Jeanie Bourke - Re: 36 Market St., BP#2014-02838 plan review comments

I have completed the review of the above project for building code and have the following comments as noted on the attached files.

A1.01

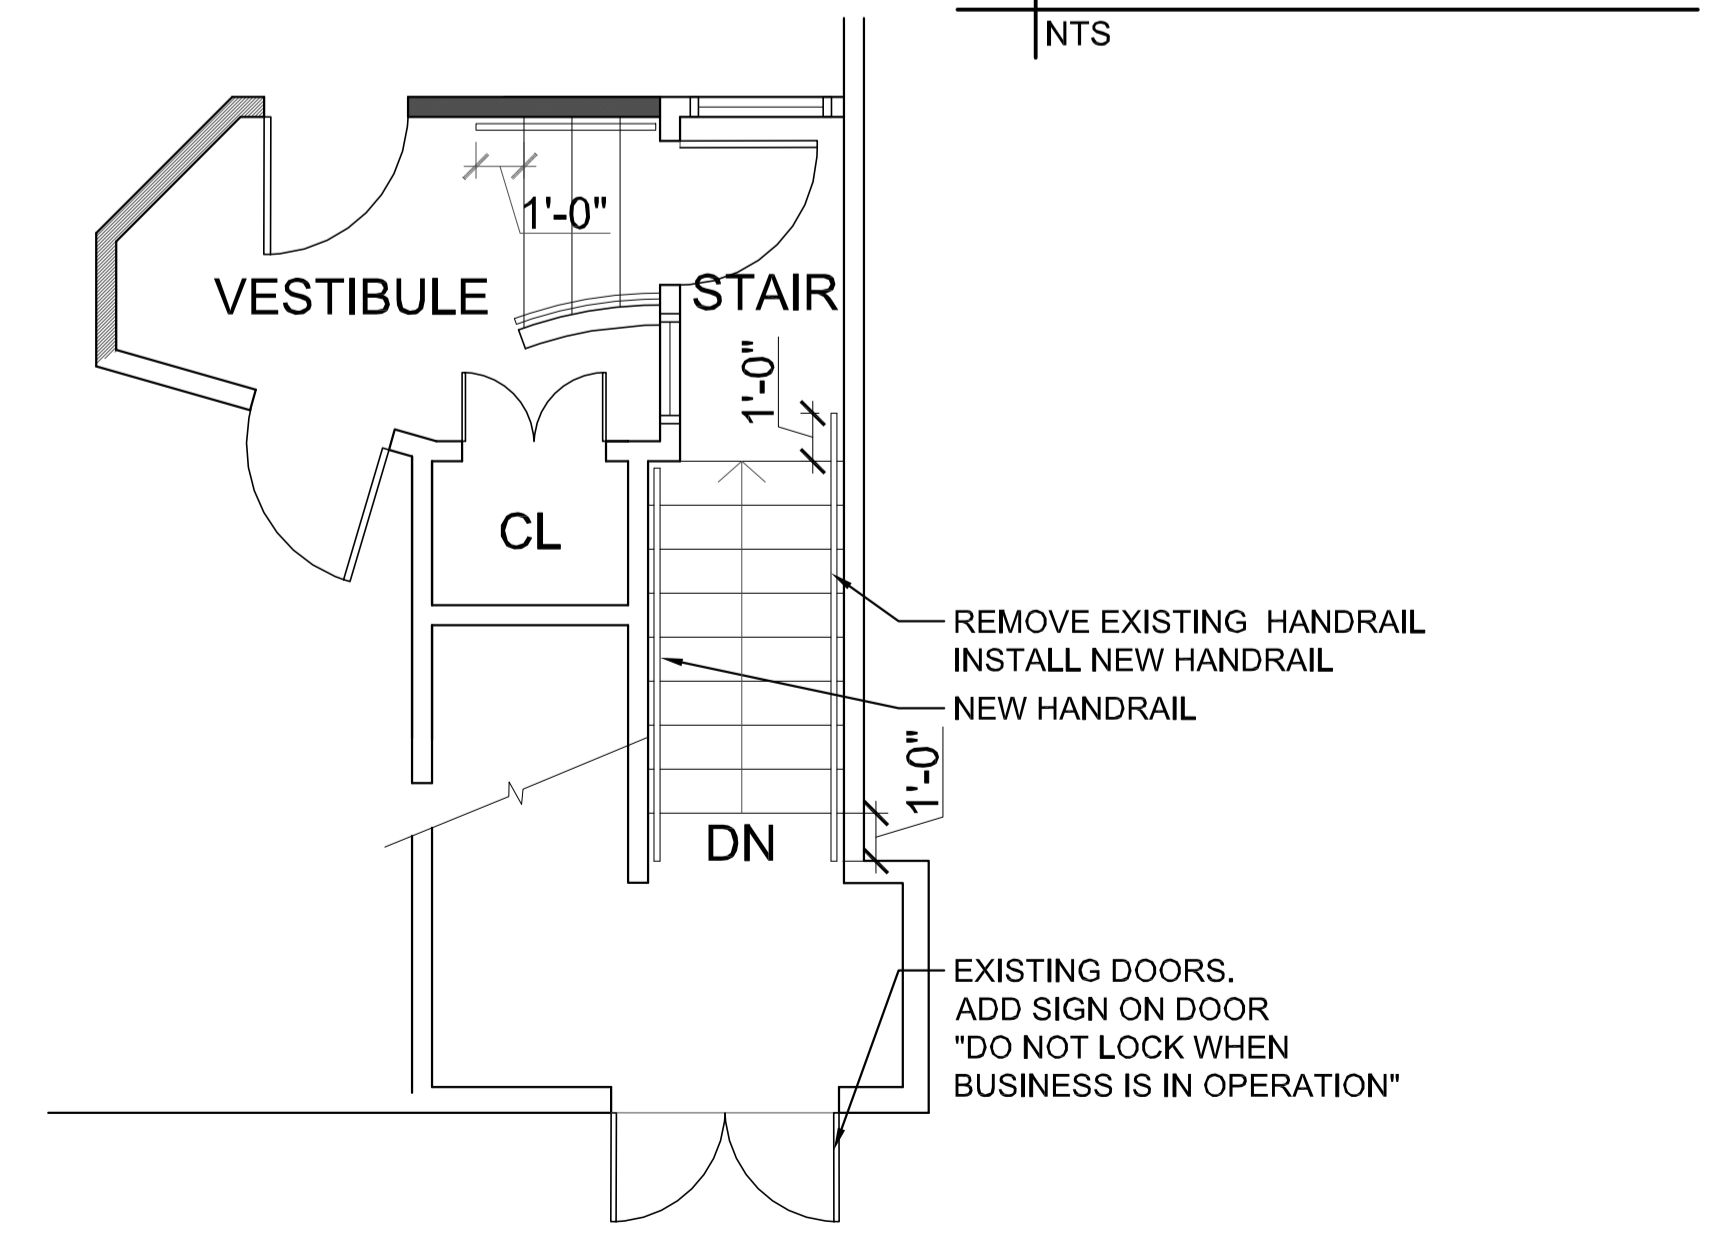
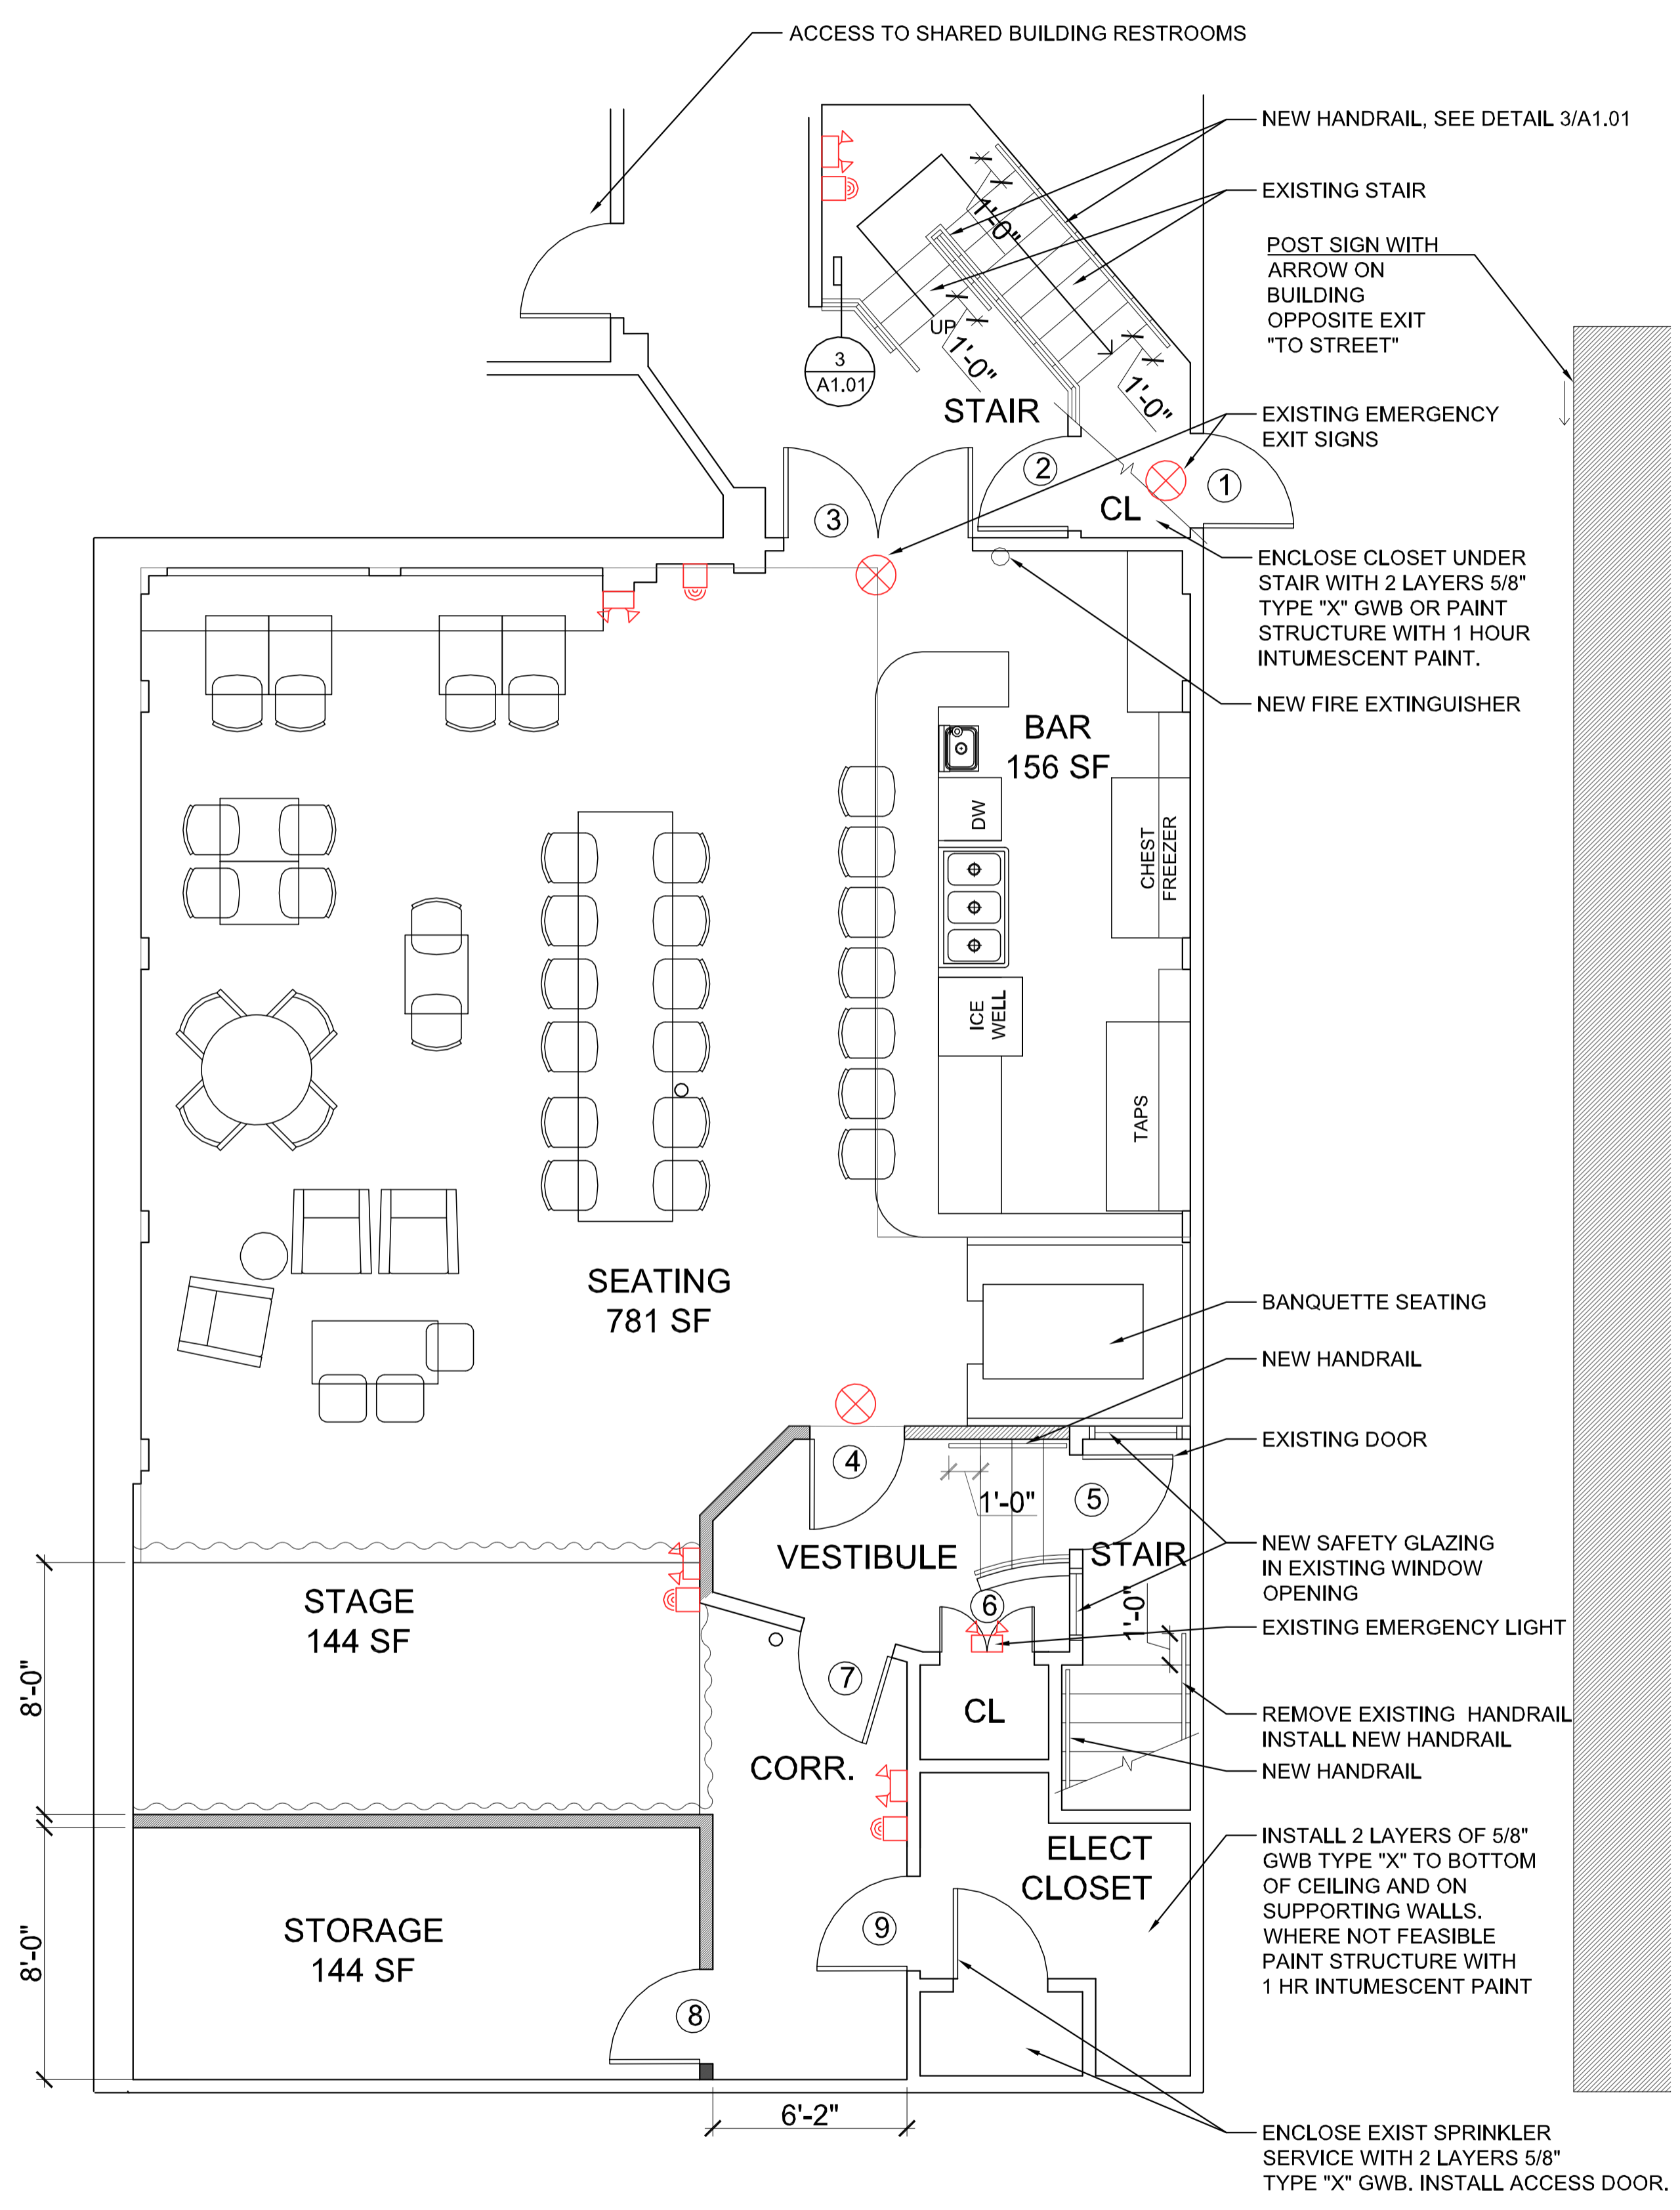
1. The bathrooms are not a part of our space. Any alterations there will be done by the landlord(ELC via 36 Market St llc) at their expense. I cannot comment on that. I understand that we will need them for our Cert of Occupancy but that space is not a part of Drinkwater Ohlson and Briggs.

2. The stage will be raised about 6-8 inches. That's it. Yes the notation in the diagram is indeed for curtains. The curtains are commercial theatre curtains and they have been submerged in professional fireproofing and have the tags sewn on them to prove it.

3. The numbers for seating/occupancy are were built off of the 781 Square feet figure that outlines the area for patrons. behind that bar will typically only accommodate one persons. Sometimes two. that's it. The stage is 144 sq feet and could technically hold 9 people however I can't imagine a time in which we would have them many individuals on it.
